From: Gregg, Robert <Robert.Gregg@lancashire.gov.uk>
Sent: 19 February 2019 14:37
To: Rebecca Bowers
Cc: planning; LHS Customer Service
Subject: APP. 3/2019/0038 - 34 DILWORTH LANE, LONGRIDGE

Application to create new driveway entrance

SITE PROPOSED PLAN
DRAWING M002
01/03/2019

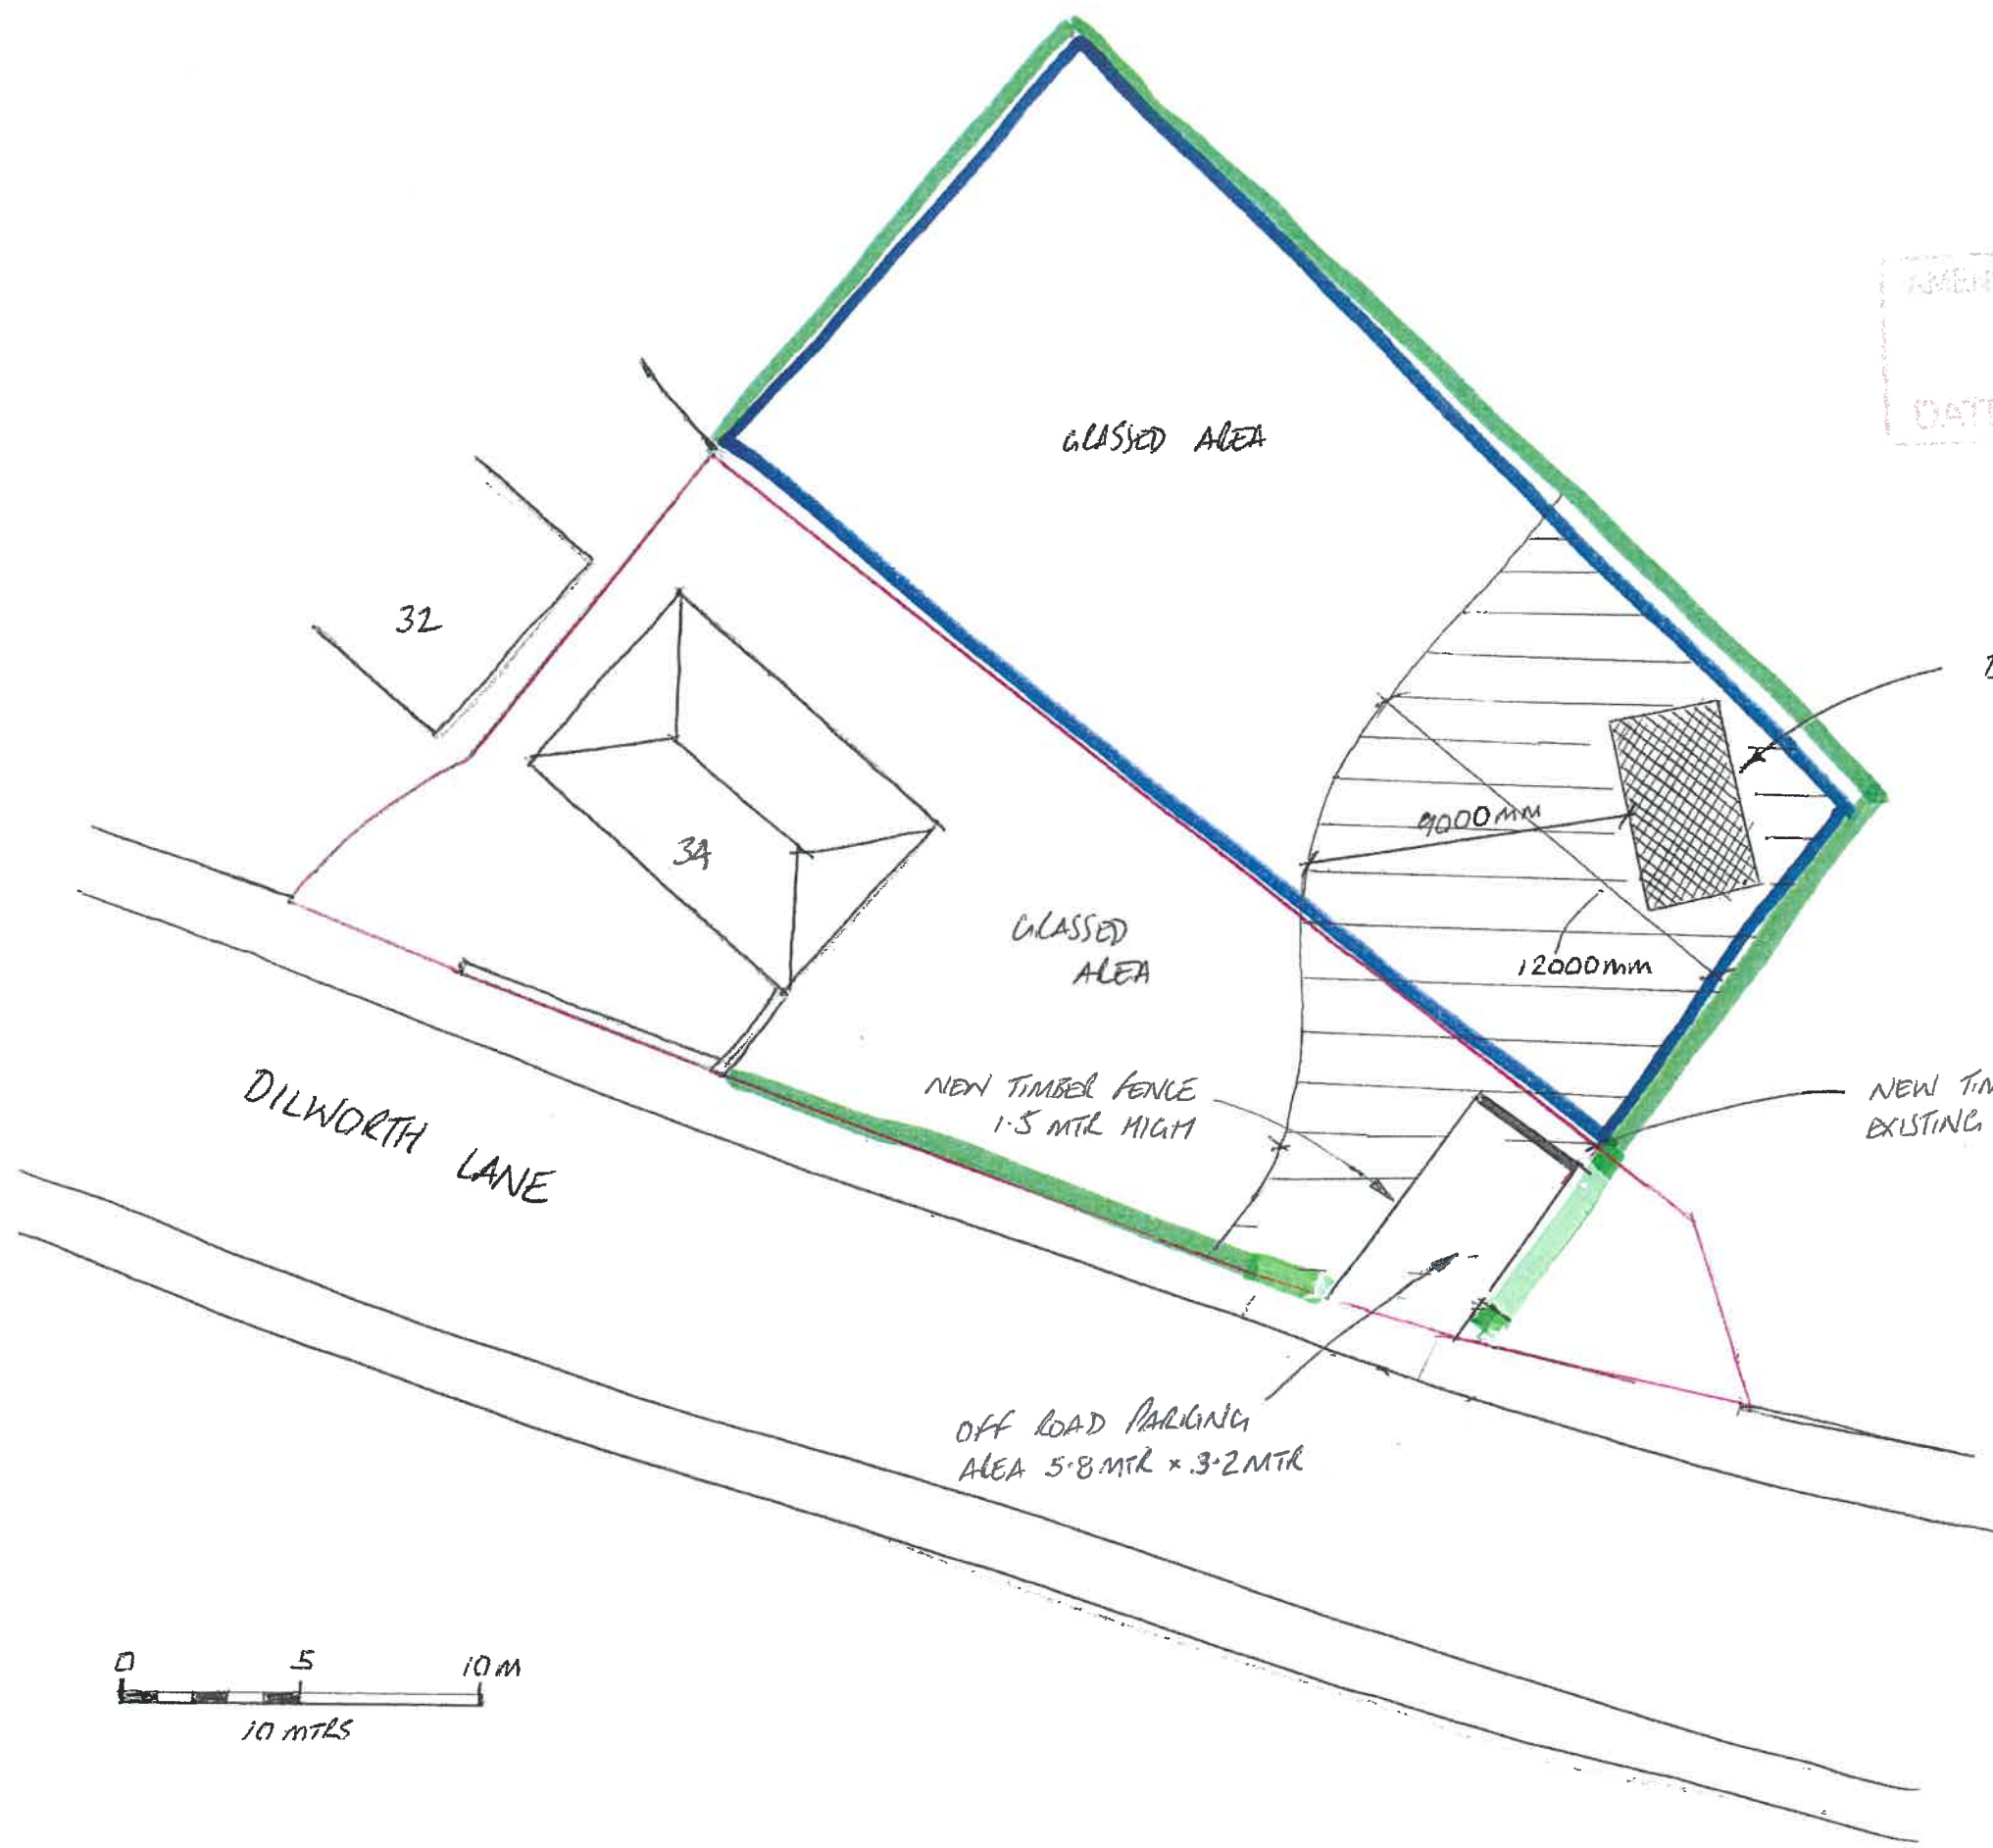
With respect to the application, I will require clarification as to the proposed parking arrangements. 34 Dilworth Lane is a 3 bedroomed dwelling with a requirement for 2 parking spaces, the proposal is to incorporate of a new driveway entrance to serve the dwelling for additional off road parking whilst also allowing vehicles to turn around within the confines of the property's boundaries.

I ask that the plans be revised, detailing the proposed parking arrangements, parking configuration and formation of the proposed hardstanding. The gated access will need to be set back 5m from the rear of the adopted footway and the access gates shall open into the site, so that any vehicles wishing to enter the new driveway can leave Dilworth Lane without the need to park within the public highway whilst the gates are opened. The formation of a dropped crossing will also need to be installed at the proposed access point whereas these works shall be carried out under Section 184 of the highways act 1980.

I ask that the plans be revised detailing the above.
